DRB Project Number: 1004428
Ceja Vista Subdivision

SUBJECT: Amended Preliminary Plat

DEVELOPMENT REVIEW BOARD - HYDROLOGY SECTION
 Renée Brissette, PE, Senior Engineer | 505-924-3995 rbrissette@cabq.gov

DRB Project Number: 1004428 Hearing Date: 3-21-2018
 Project: Ceja Vista, Tracts RR-3-A, RR-3-B, RR-3-C, RR-3-D, & RR-3-E Agenda Item No: 9

TITLE: **CEJA VISTA SUBDIVISION - UNIT 1  
GRADING & DRAINAGE PLAN**

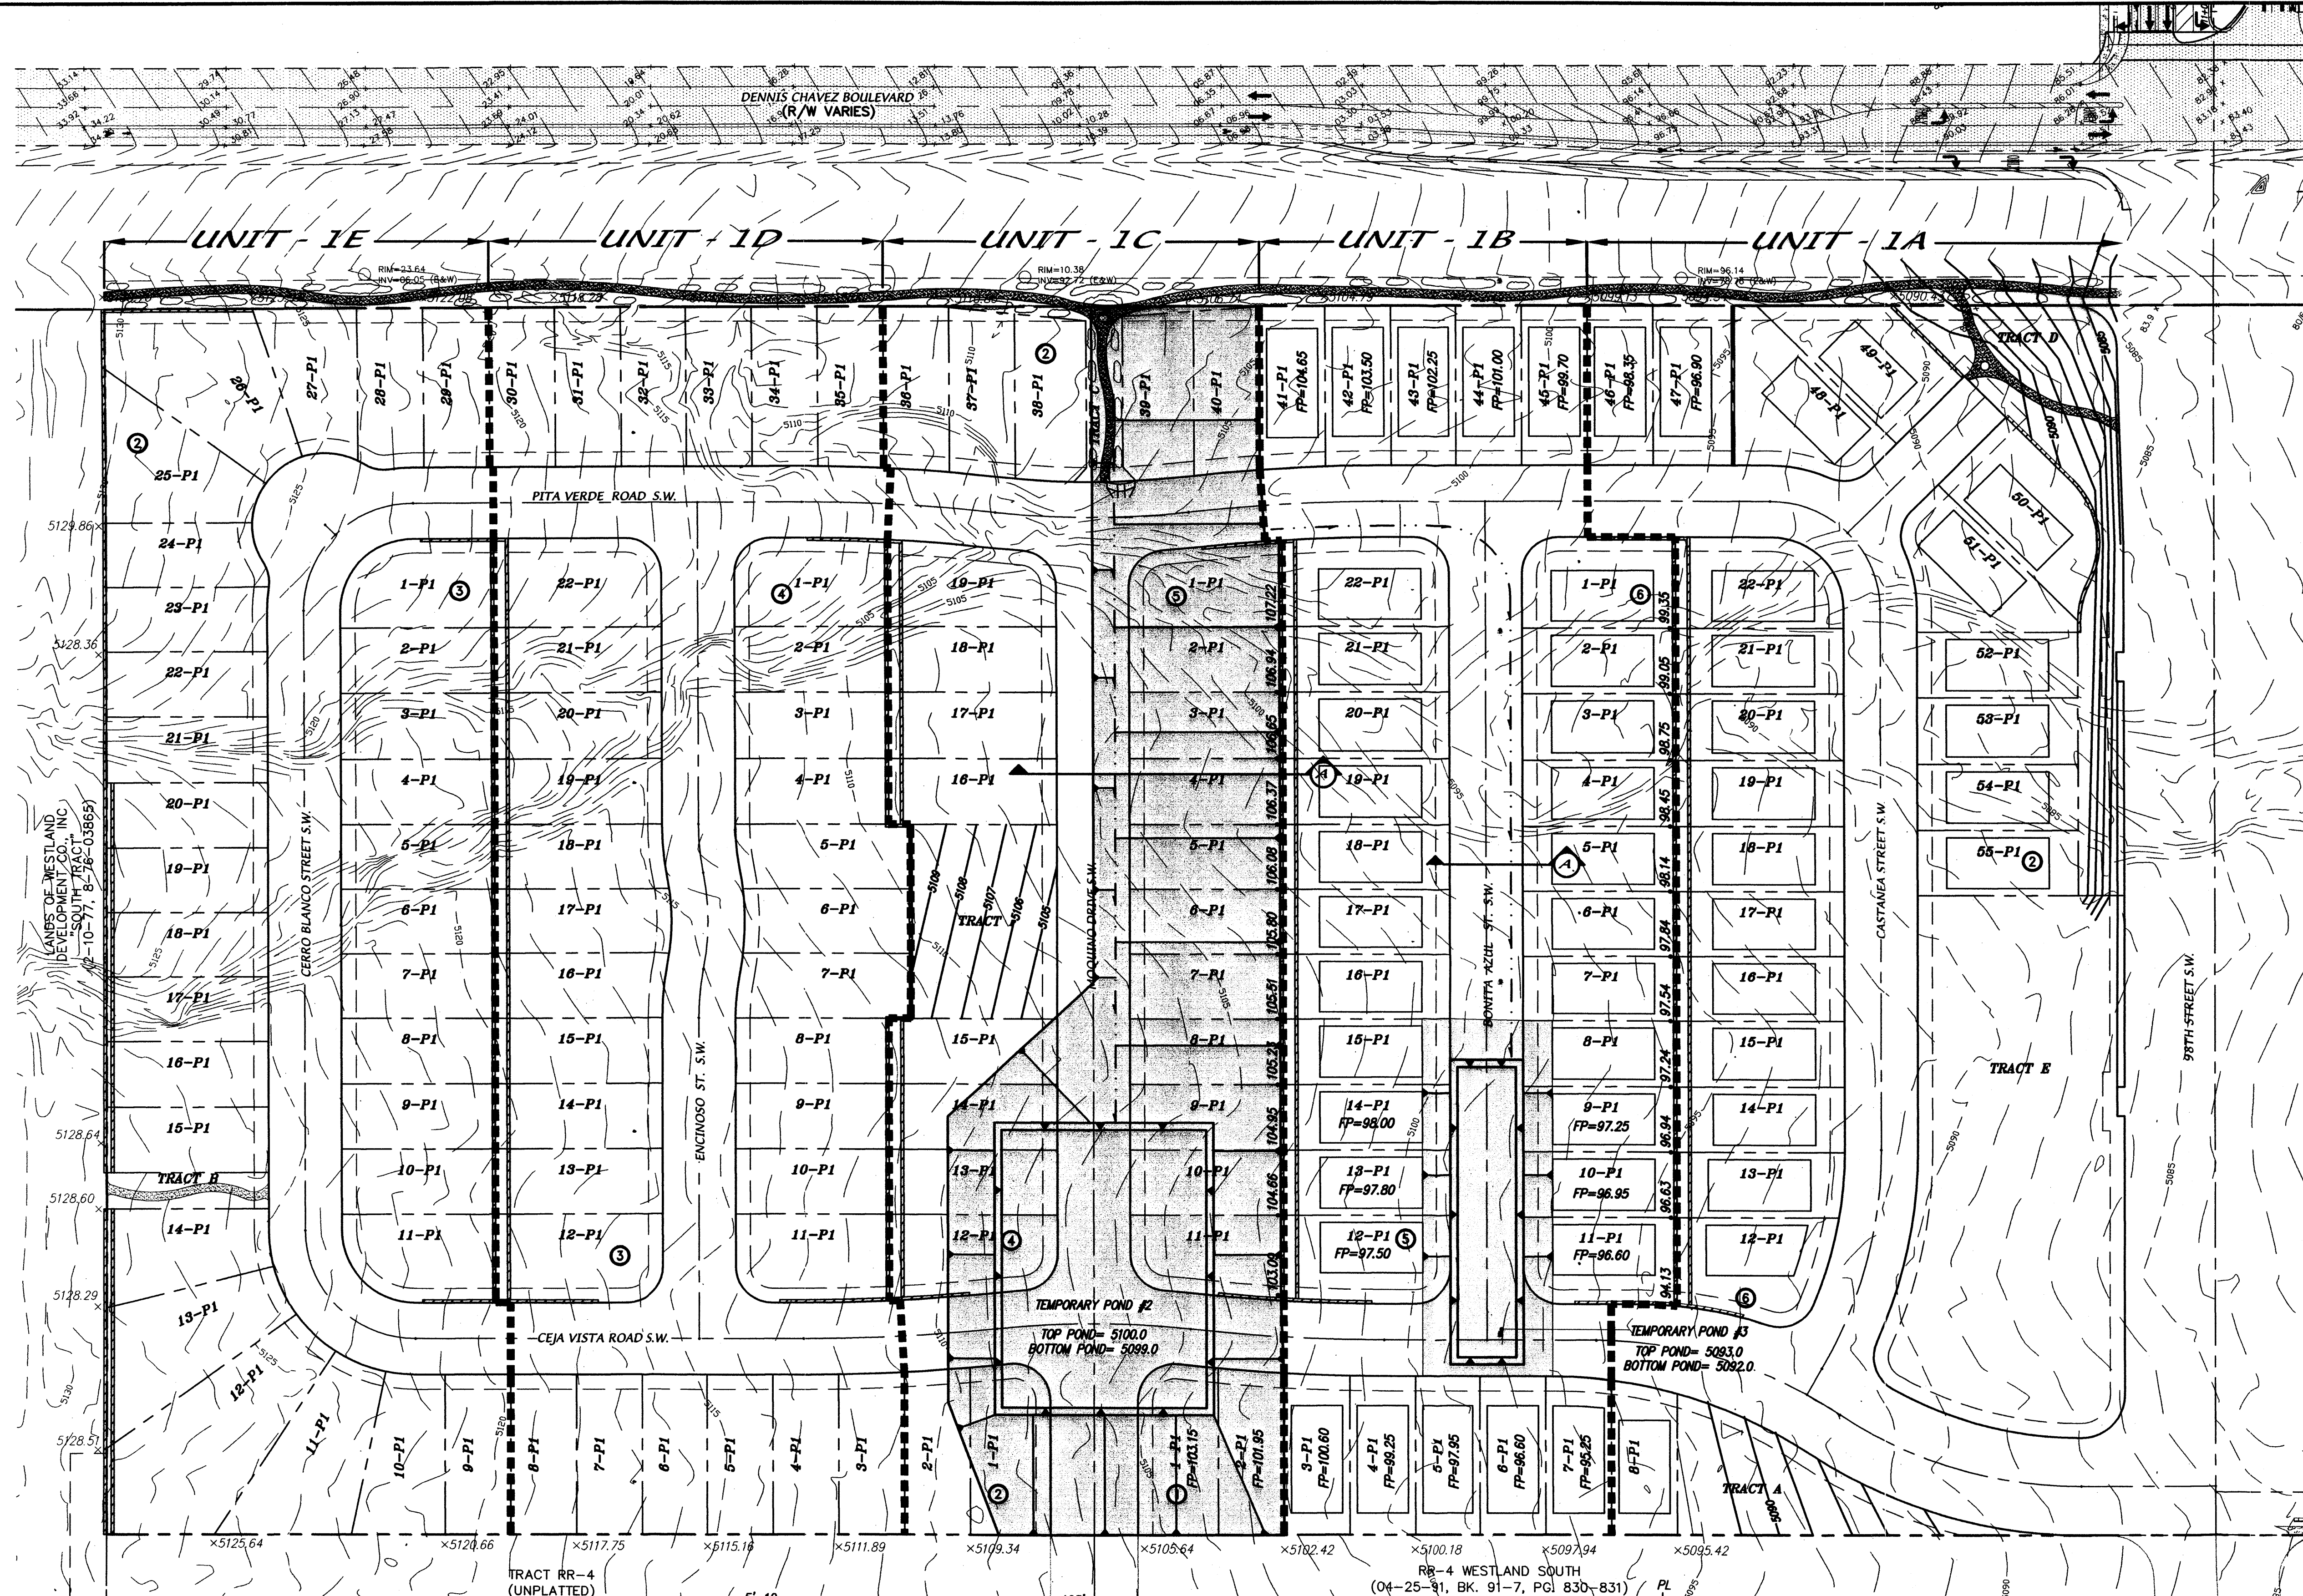
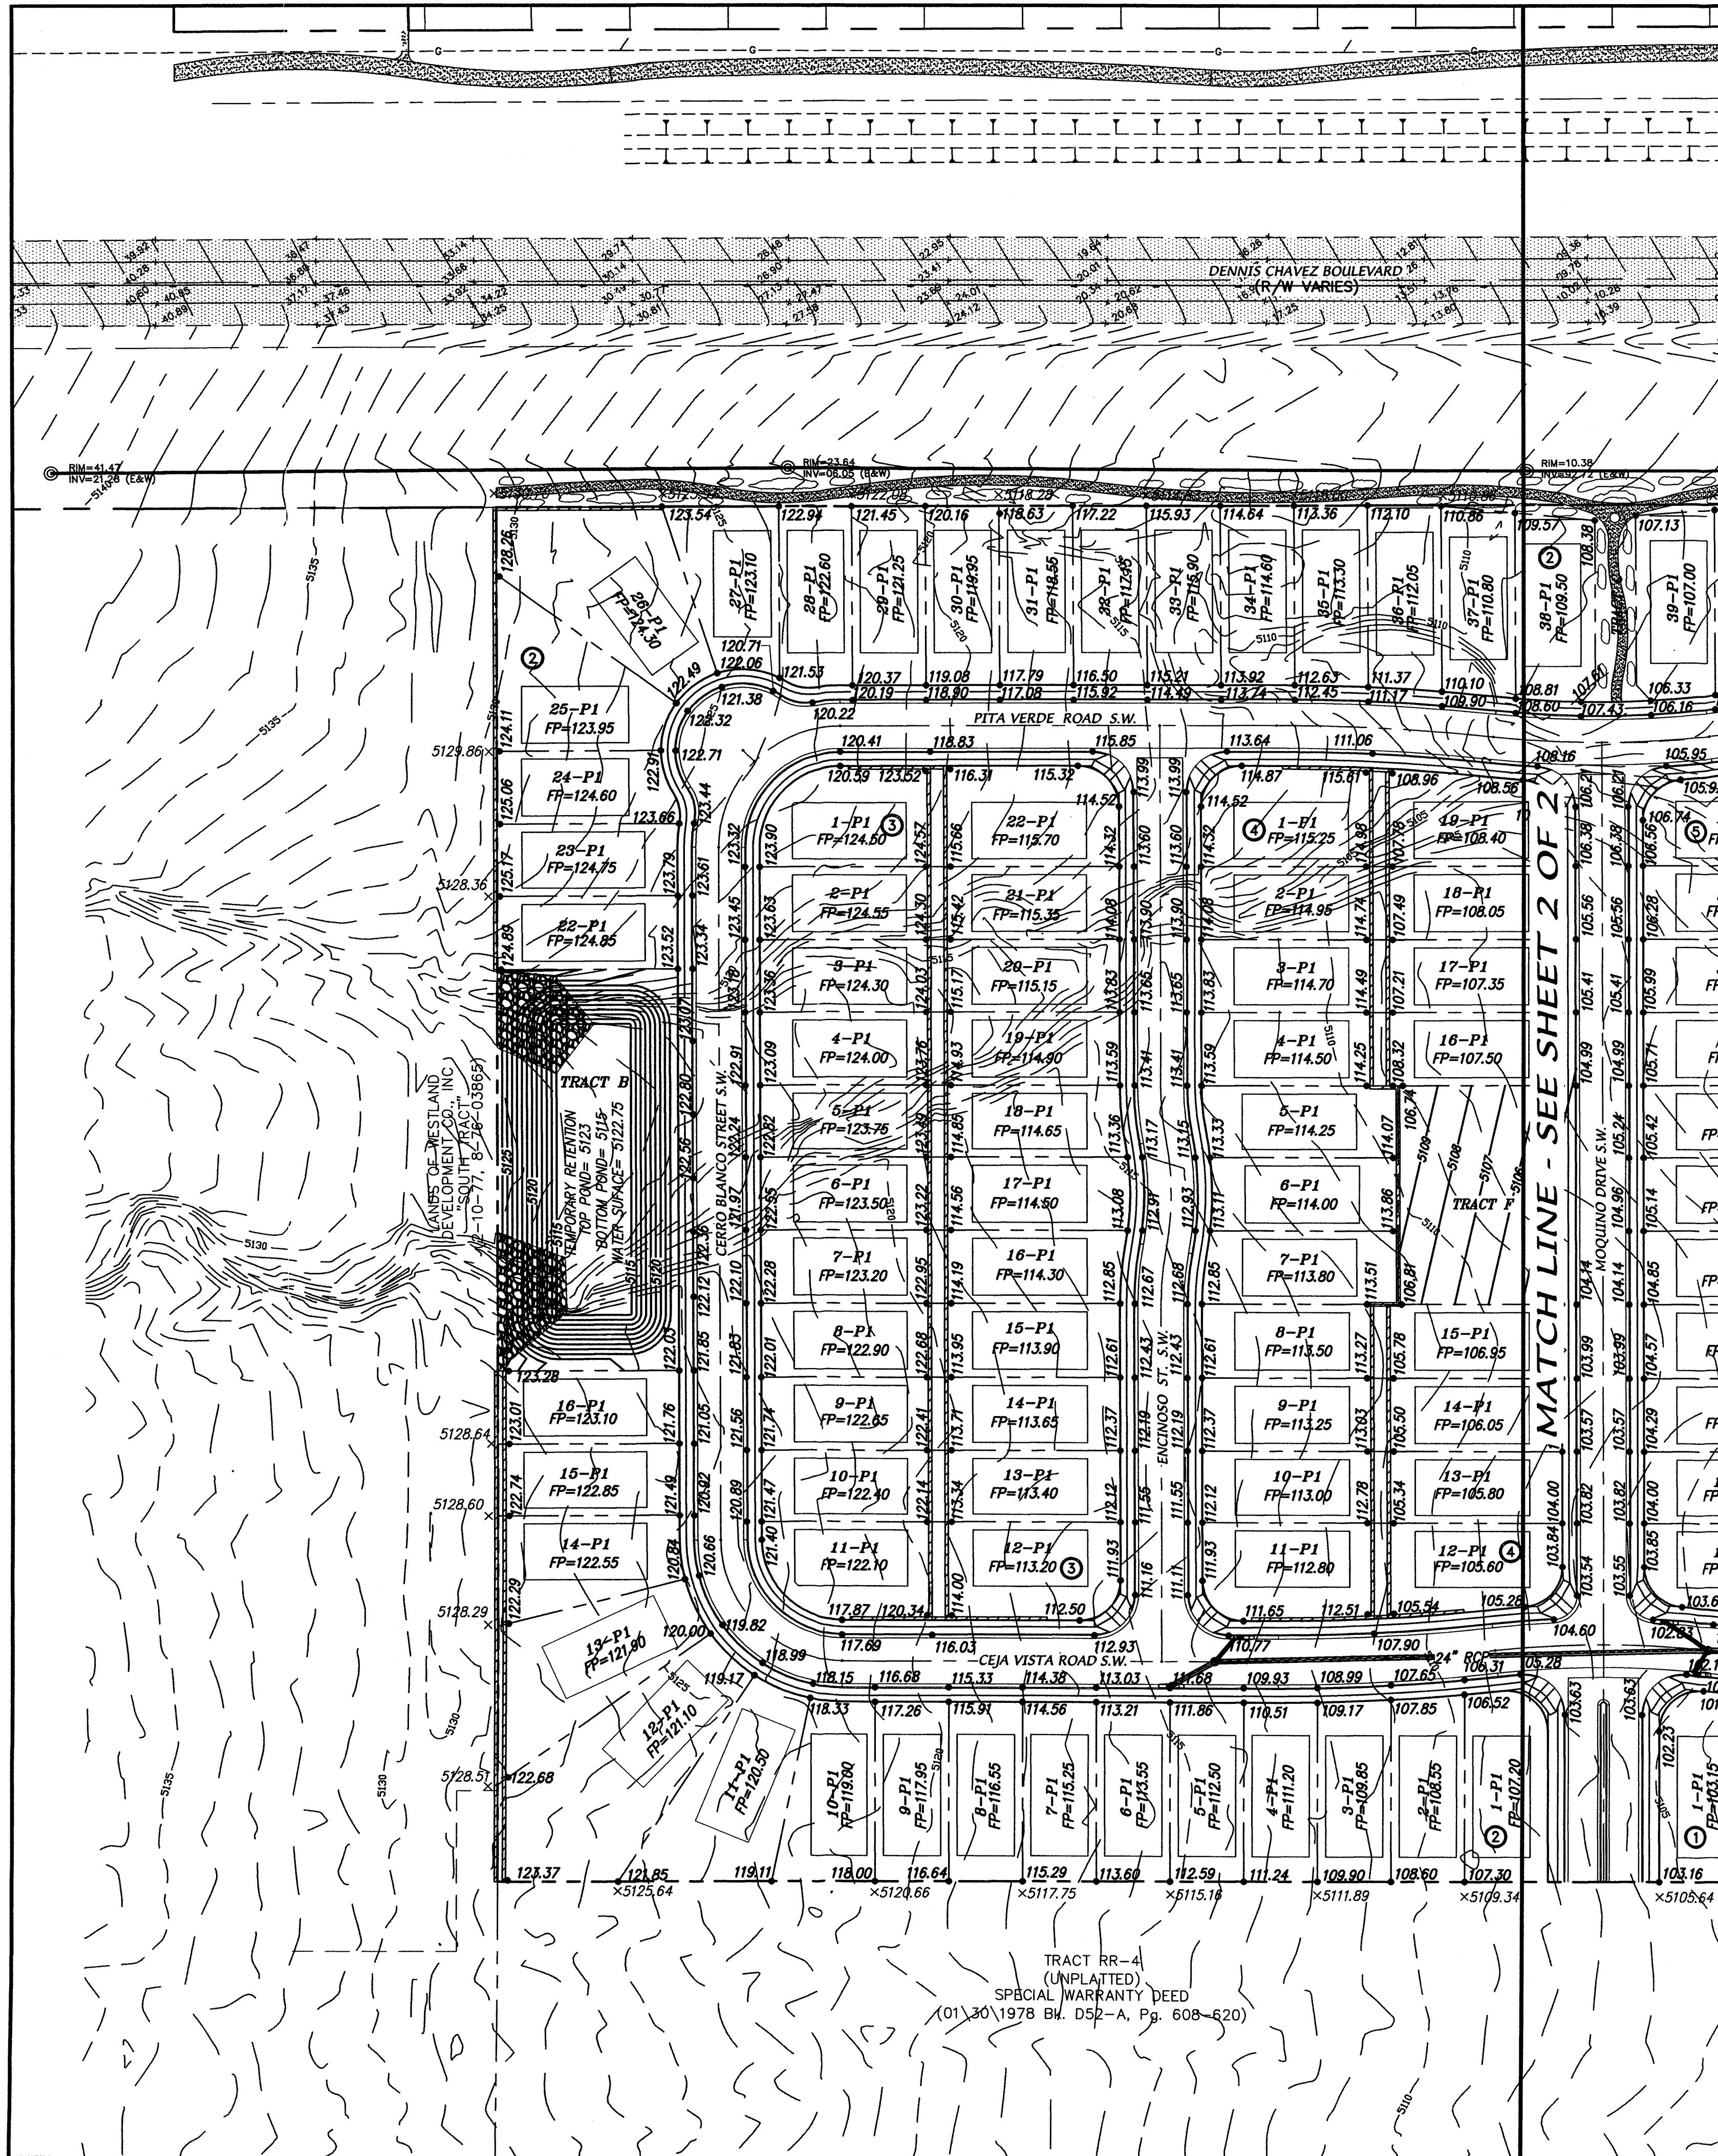
- Grading Plan and Drainage Report must be approved by Hydrology prior to Hydrology's signature of the Infrastructure List.
 - The Grading and Drainage plan needs to address the First Flush requirement.

- This should include drainage swale and a culvert crossing at 98th within Dennis Chavez. Also needs to identify who is going to maintain the open ditch and culverts. Hydrology will need an approval letter from them stating that they are going to maintain the open ditch and culverts.
